M3 Junction 9 Improvement

Scheme Number: TR010055

8.6 Applicant Response to Written Summaries of Oral Submissions at Open Floor Hearing 1 (OFH1)

15 June 2023

DRAWING TITLE  
 FIGURE 2.6 - THE SCHEME: TEMPORARY DIVERSION OF WALKING, CYCLING, AND HORSE RIDING ROUTES APFP REGULATIONS 5(2)(a) DOCUMENT REFERENCE 6.2

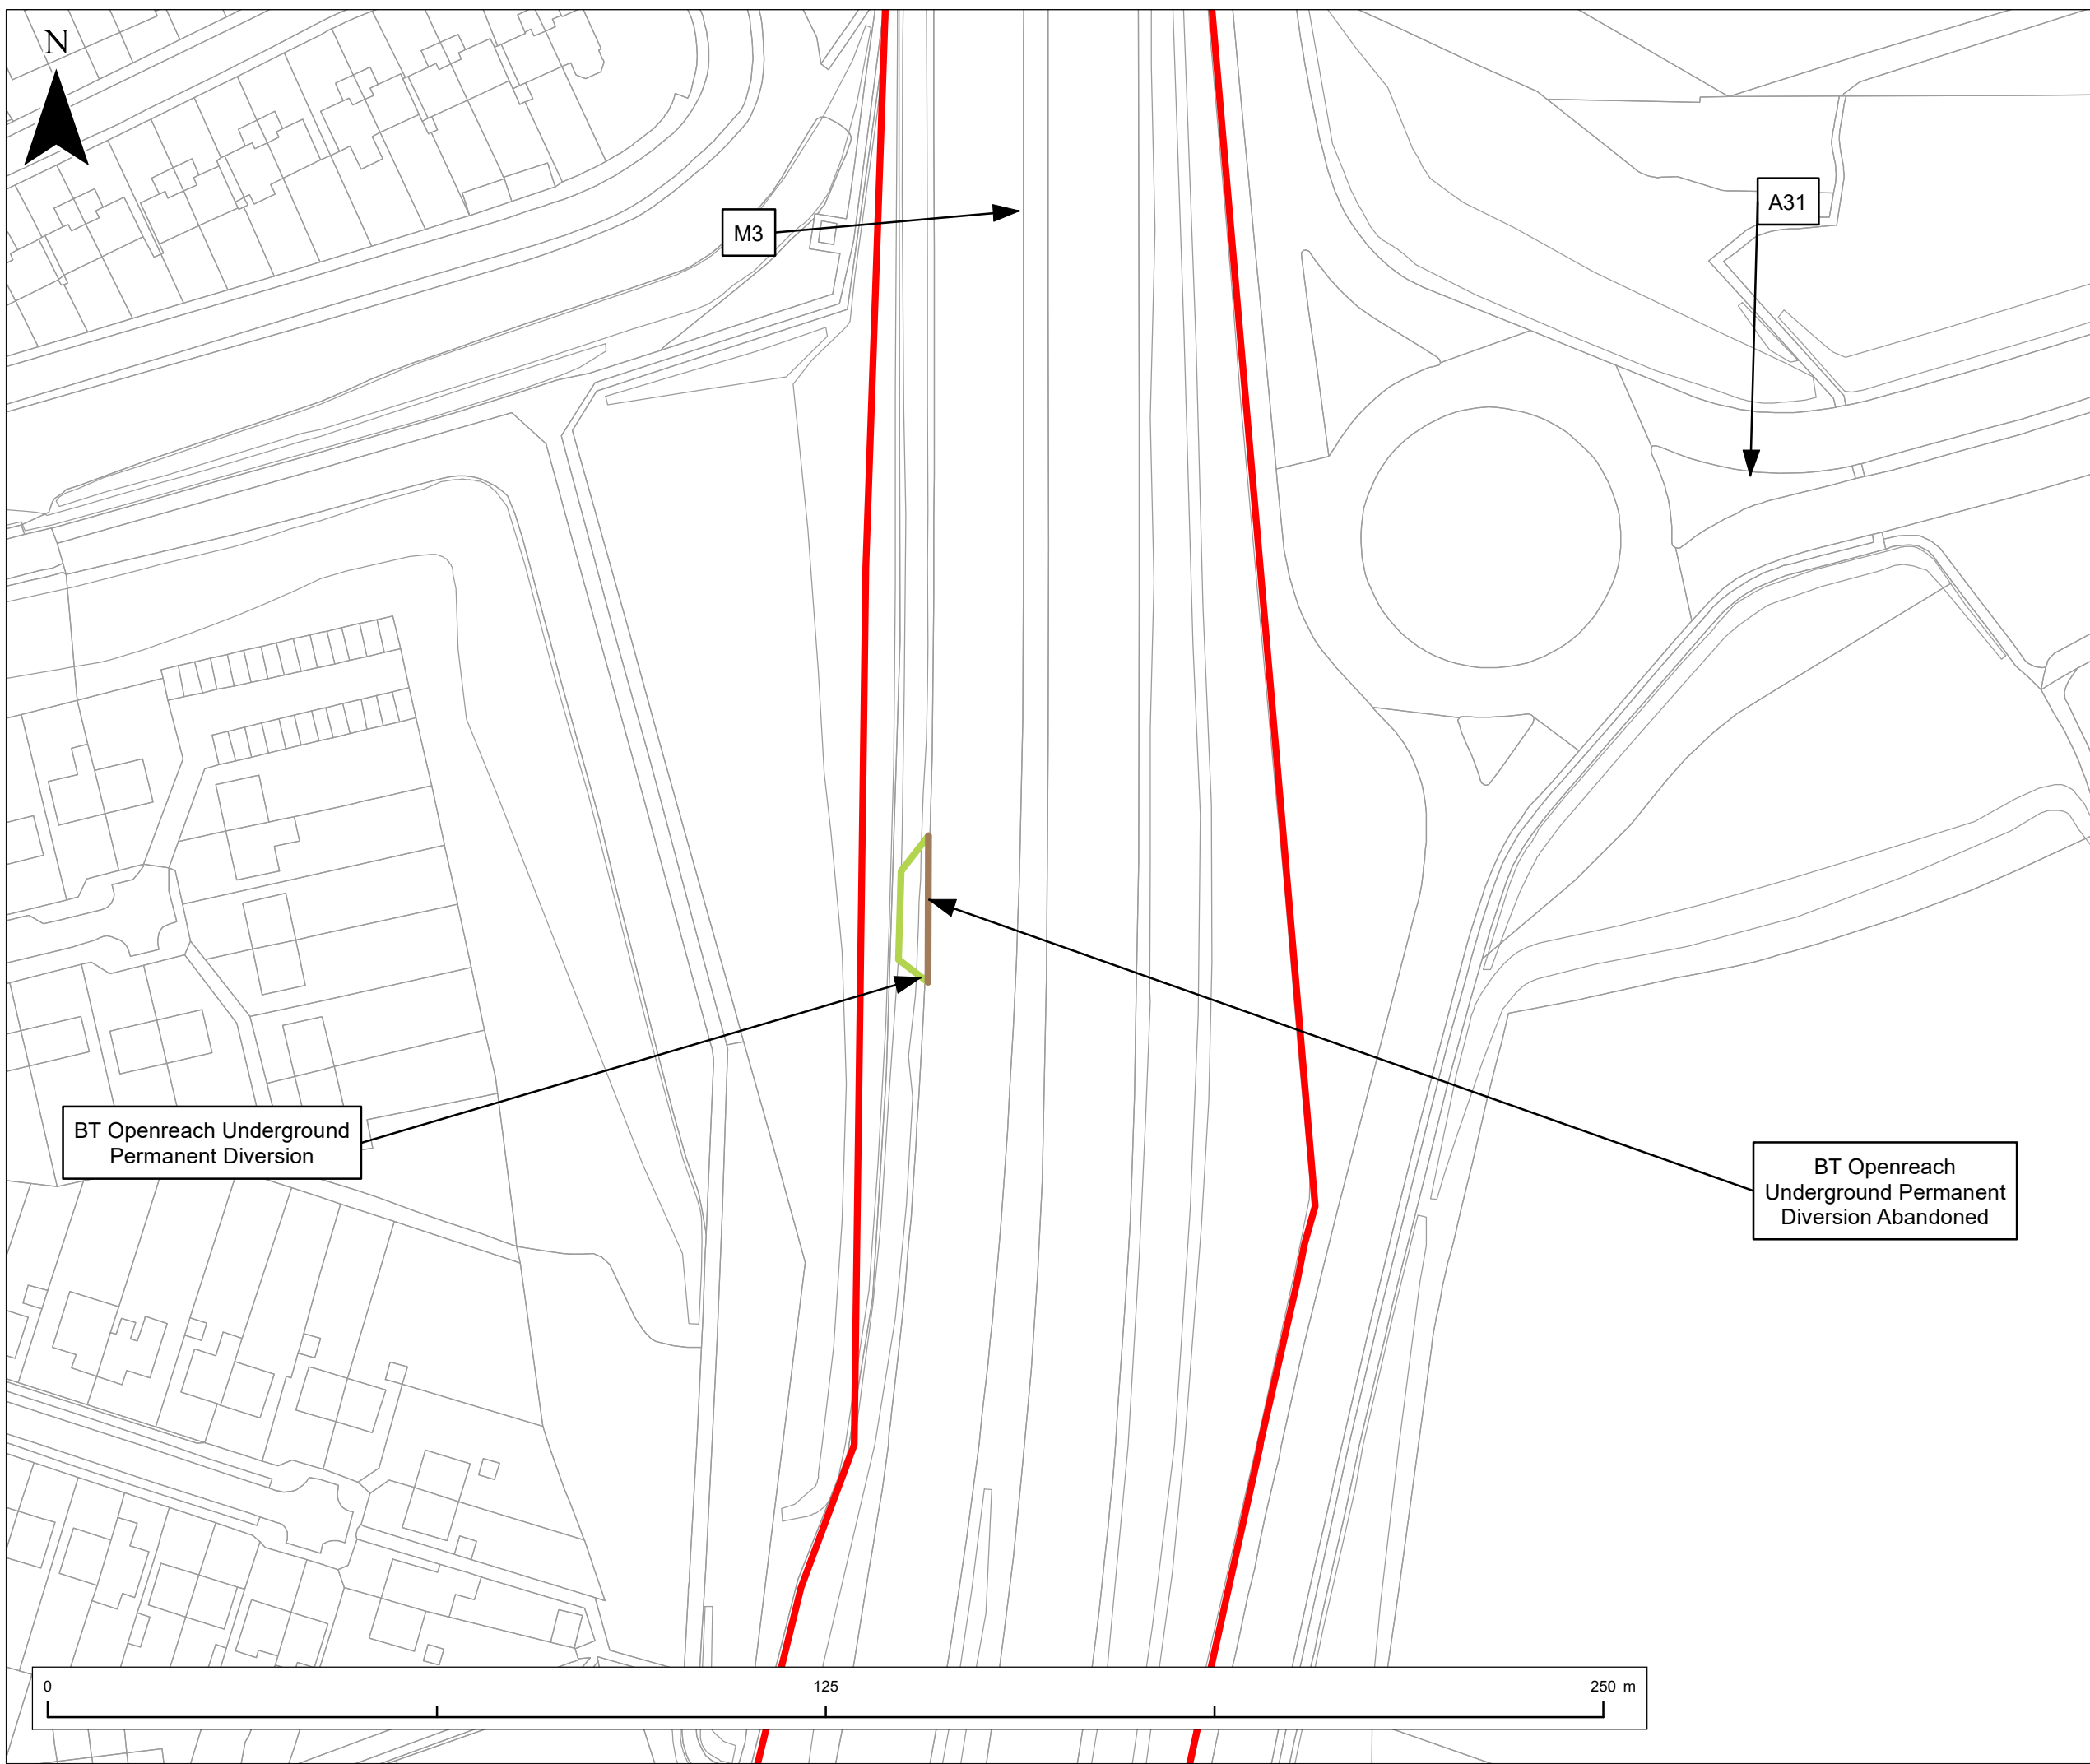
Summary of Oral Representation	Applicant's Response
<p>amount of surface run-off cannot be fully understood.</p> <p>[Extract from General Arrangement Plans provided in REP1-035]</p> <p>The borehole and the infiltration basin are situated at a low point in the landscape and we are concerned that our drinking water supply will become contaminated. The costs and disruption of a new borehole sited away from the basin, or the installation of mains water and future water costs would be considerable.</p> <p>I am concerned about Long Walk being used for access by works traffic. [REDACTED] are accessed only via Long Walk, a narrow lane which includes a bridge beneath the M3. The resident [REDACTED] is very concerned about the impact the works will have on her property. Several PRow converge near Fulling Mill (Itchen Valley Footpaths 20, 21, 22, 49, 52 and Restricted Byeway 19) and during works access will be restricted. Several of these paths are currently in need of maintenance. Once the new bridleway opens these paths should see increased use and will need to be improved and maintained accordingly.</p>	<p>With regards to light pollution, Chapter 7 (Landscape and Visual) of the Environmental Statement (ES) (6.1, Rev 1) considers the effects of light pollution during both construction and operation of the Scheme. As stated in the first iteration Environmental Management Plan (fiEMP) (7.3, Rev 2): <i>'There will be static lighting points fixed to temporary structures such as the masts, cabins, workshops, gantry cranes and silos with the lamps up to 10m in height. These will be used to illuminate regularly used work areas, the car park and access areas. Baffles will be installed on all lighting columns and light is to be angled to face works.'</i></p> <p>It is the Applicant's understanding that the borehole detailed as Mansard House is the location referred to by Ms Rosewell, near to the Shoulder of Mutton Farm off Easton Lane. This borehole for private groundwater abstraction is shown on Figure 3.14 'Licenced and private abstractions and SPZs' of Appendix 13.2: Hydrogeological Risk Assessment (6.3, APP-144) and is 90m east of the Application Boundary. The borehole is up the hydraulic gradient of the proposed works which means that groundwater flowing past Drainage Basin 5 will be flowing away from the borehole. It is therefore considered to have a negligible risk of impacting it.</p> <p>Walking, cycling and horse-riding route closures and associated diversions would be avoided unless absolutely necessary. However, due to the nature of the work required on the M3 Junction 9 gyratory, there would be a diversion required to the National Cycle Network (NCN) Route 23 as the new gyratory abutments are constructed. Please refer to Figure 2.6 (Temporary diversion of walking, cycling and horse-riding routes) of Chapter 2 (The Scheme and its Surroundings – Figures (Part 3 of 4)) of the ES (6.2, APP-063) which shows two temporary diversion routes for NCN 23.</p>
